Re: Forest Ridge Phase 1 (LPF-20-00005) Final Long Plat

This letter is to address your December 29<sup>th</sup>, 2020 letter requesting additional information. Below is a description of how each request is being addressed by the applicant:

**FOREST RIDGE - PHASE I
PERFORMANCE BASED CLUSTER PLAT**
A PORTION OF SECTION 24, TOWNSHIP 20 N., RANGE 15 E.
KITITAS COUNTY, WASHINGTON

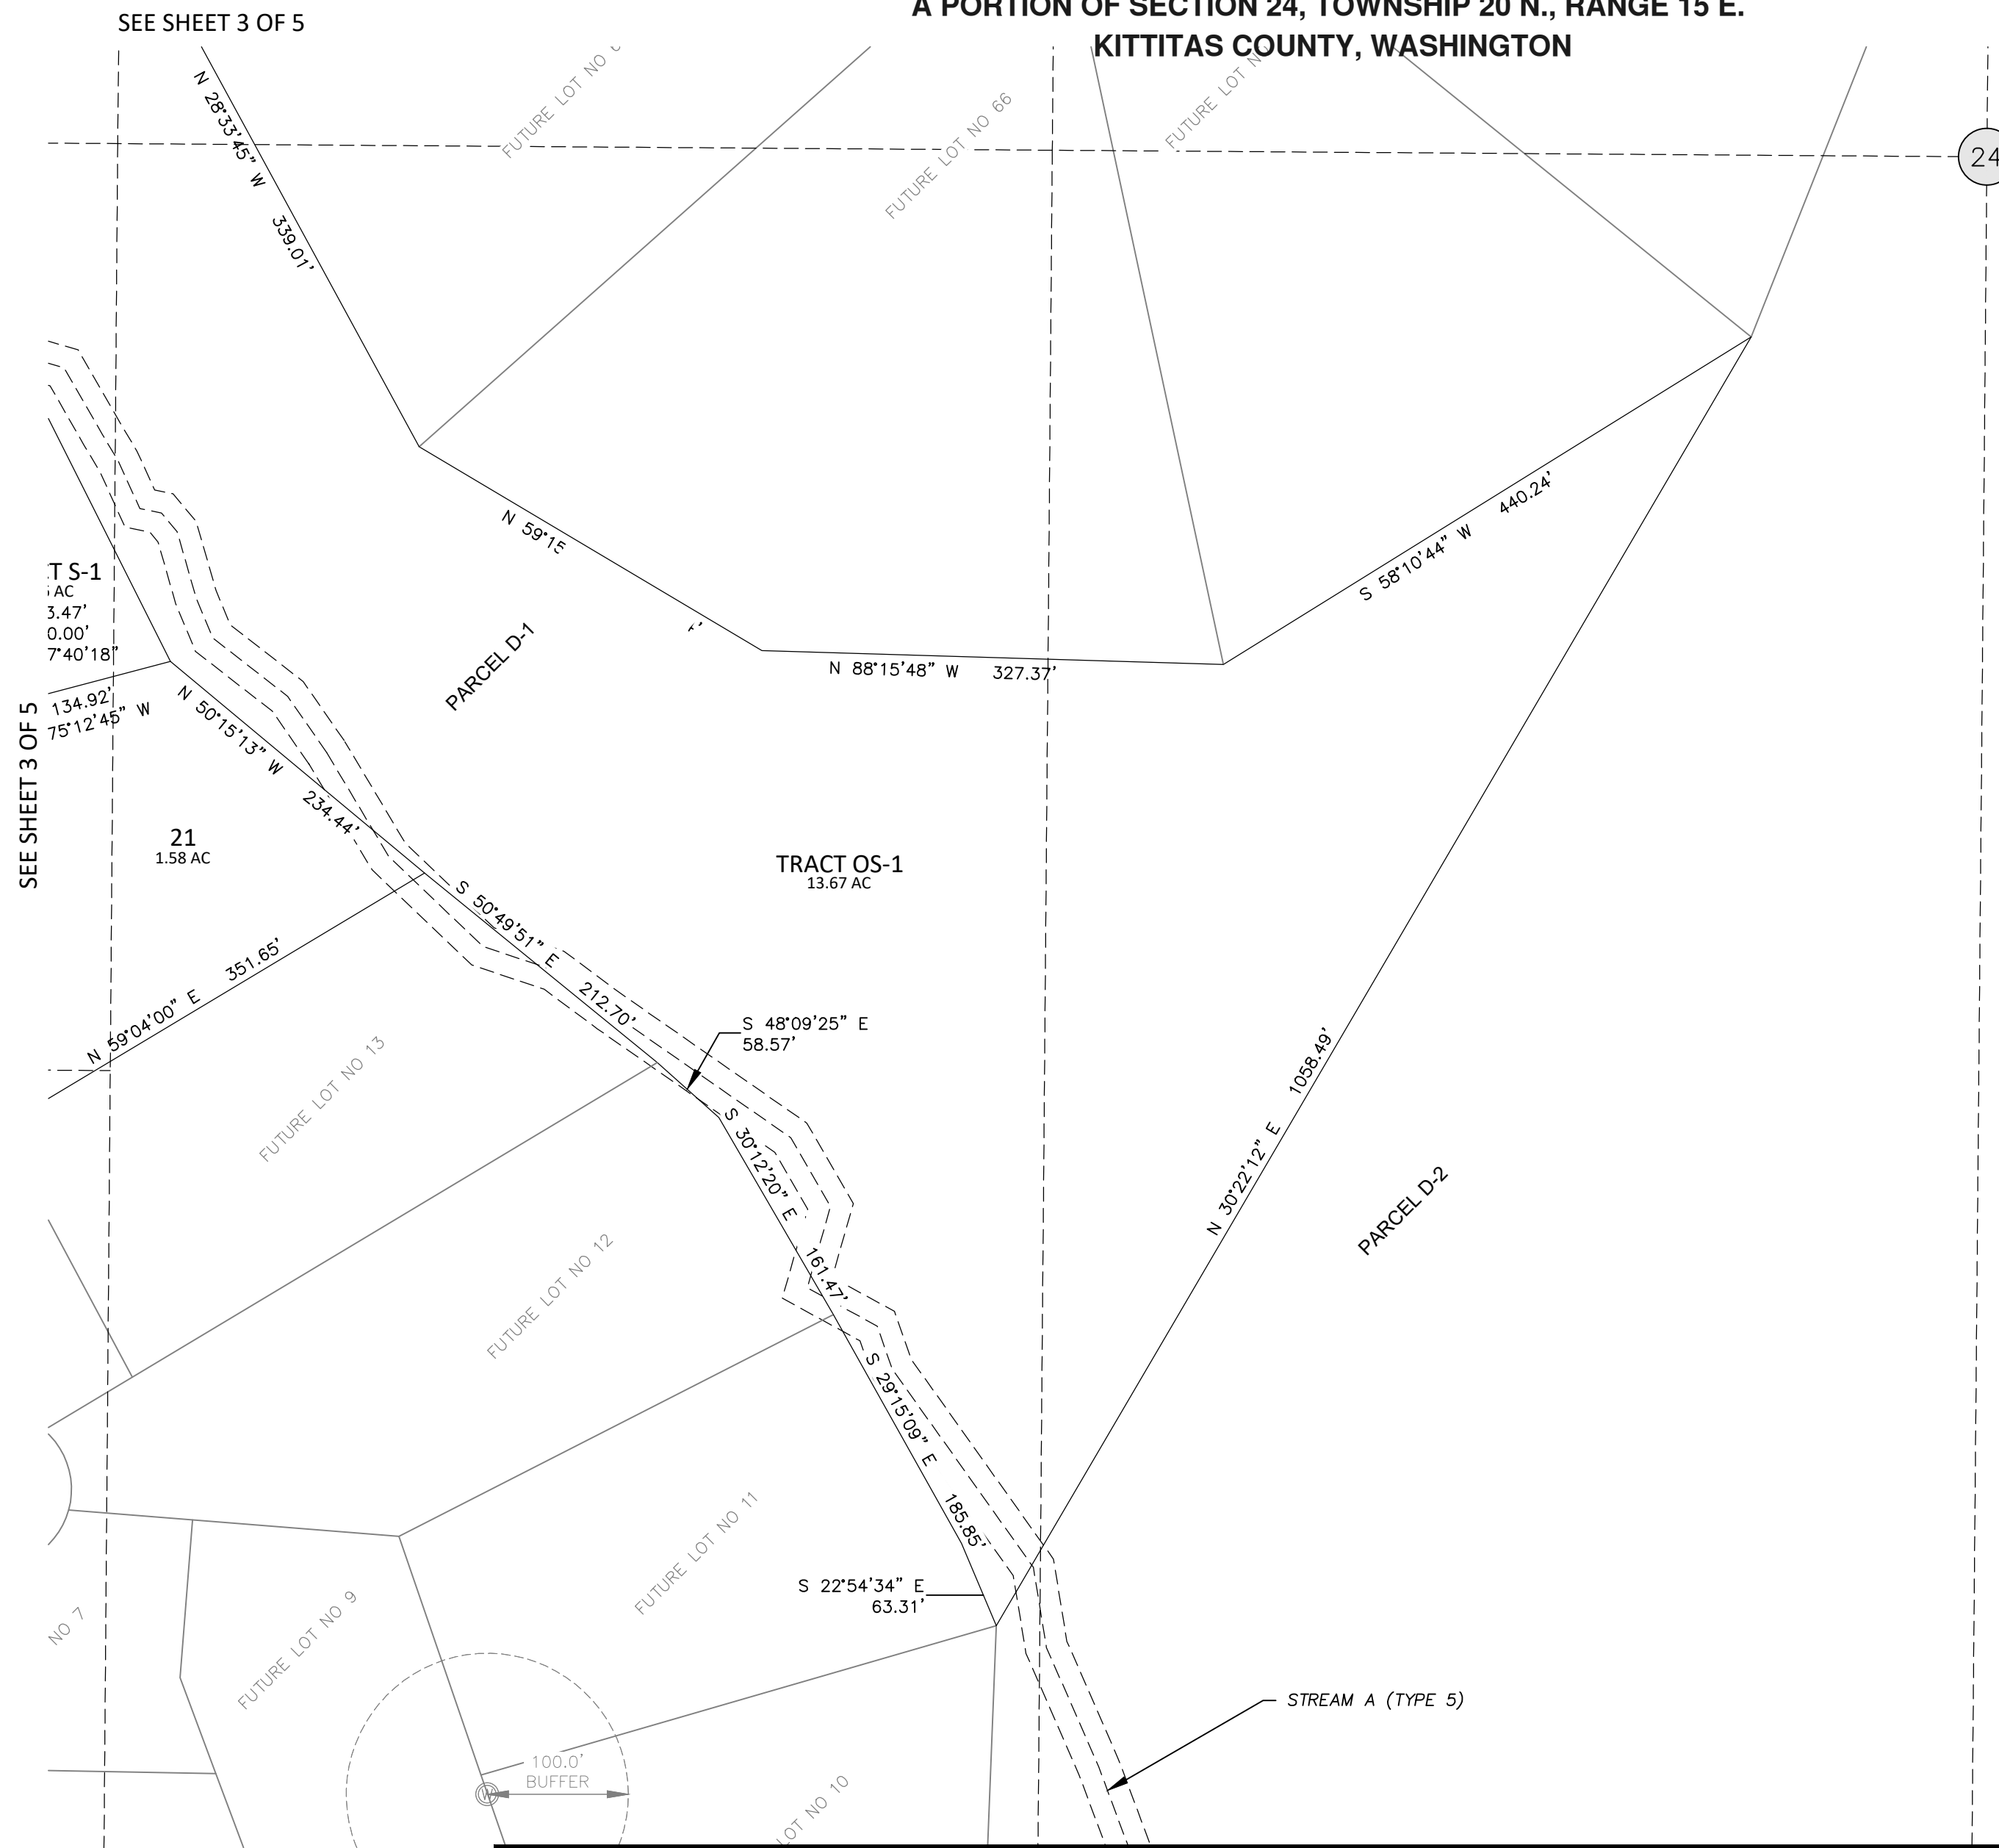
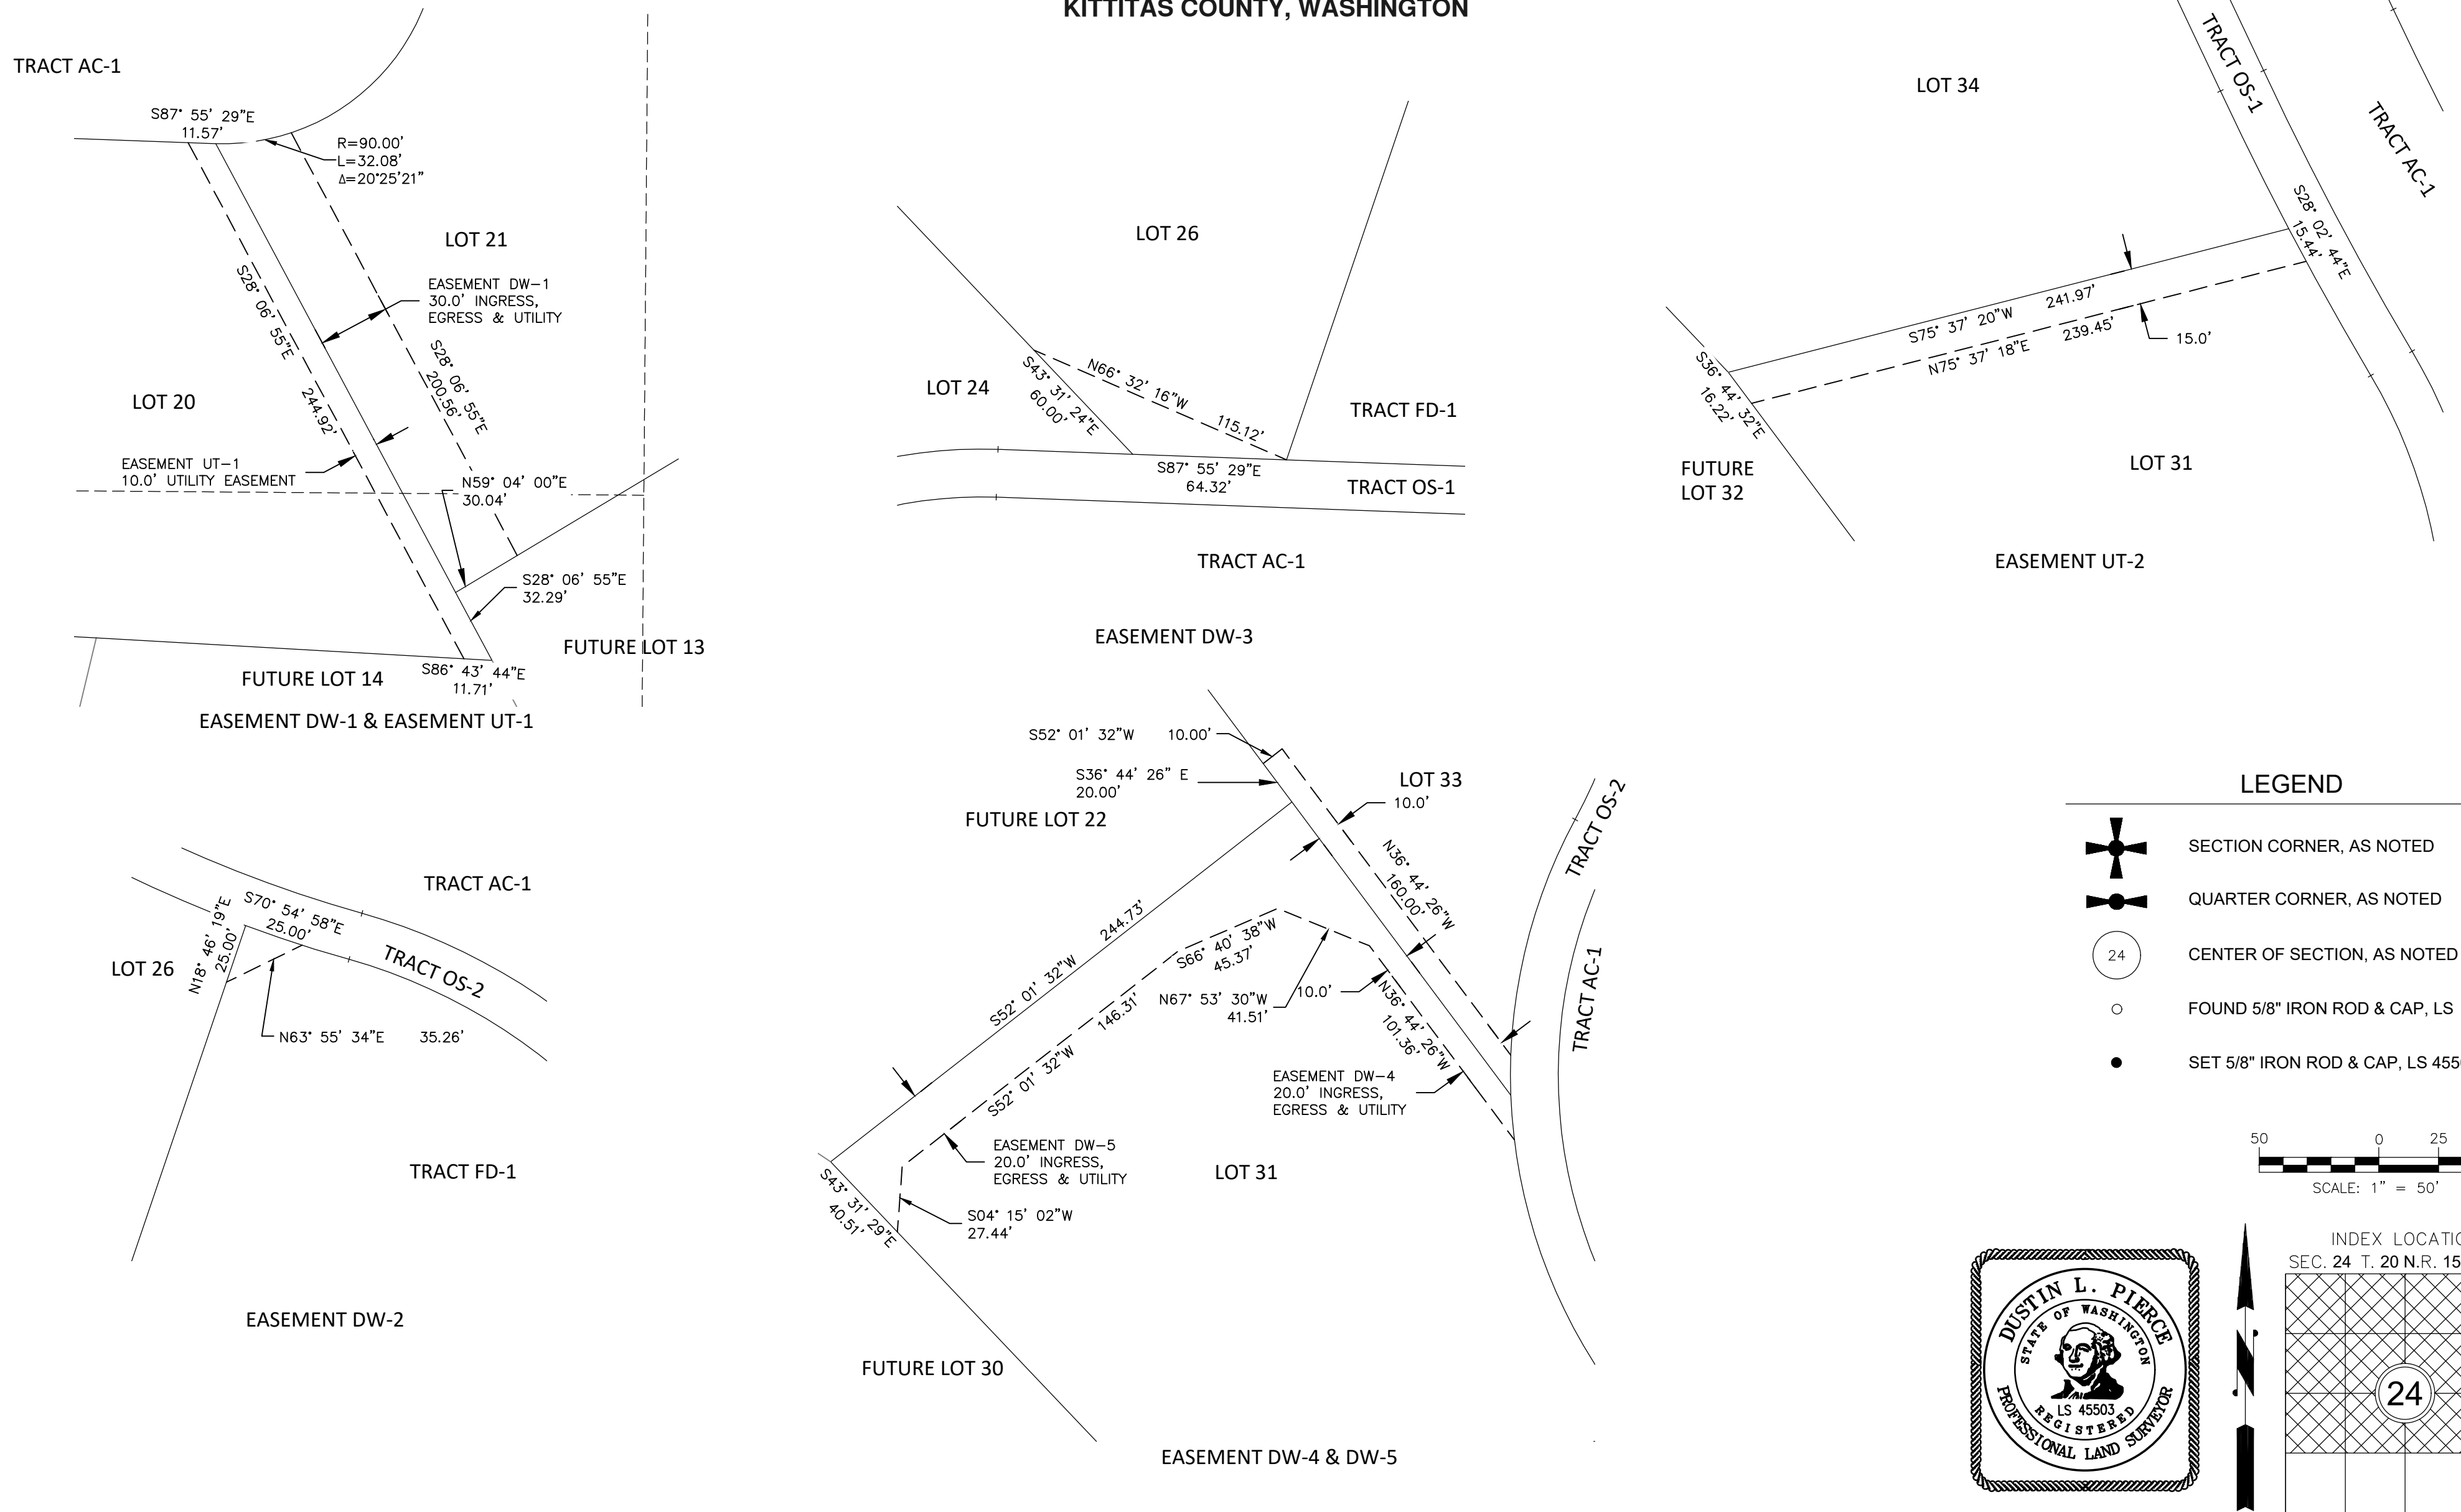
- *Wetlands "A" and "B" as depicted on the attached wetland inventory map are not noted on the preliminary survey. Condition #11 of Resolution 2010-137 requires, "All wetland areas and their buffers shall be shown on the face of the final plat." **See enclosed plat map with Wetlands "A" and "B" shown.***
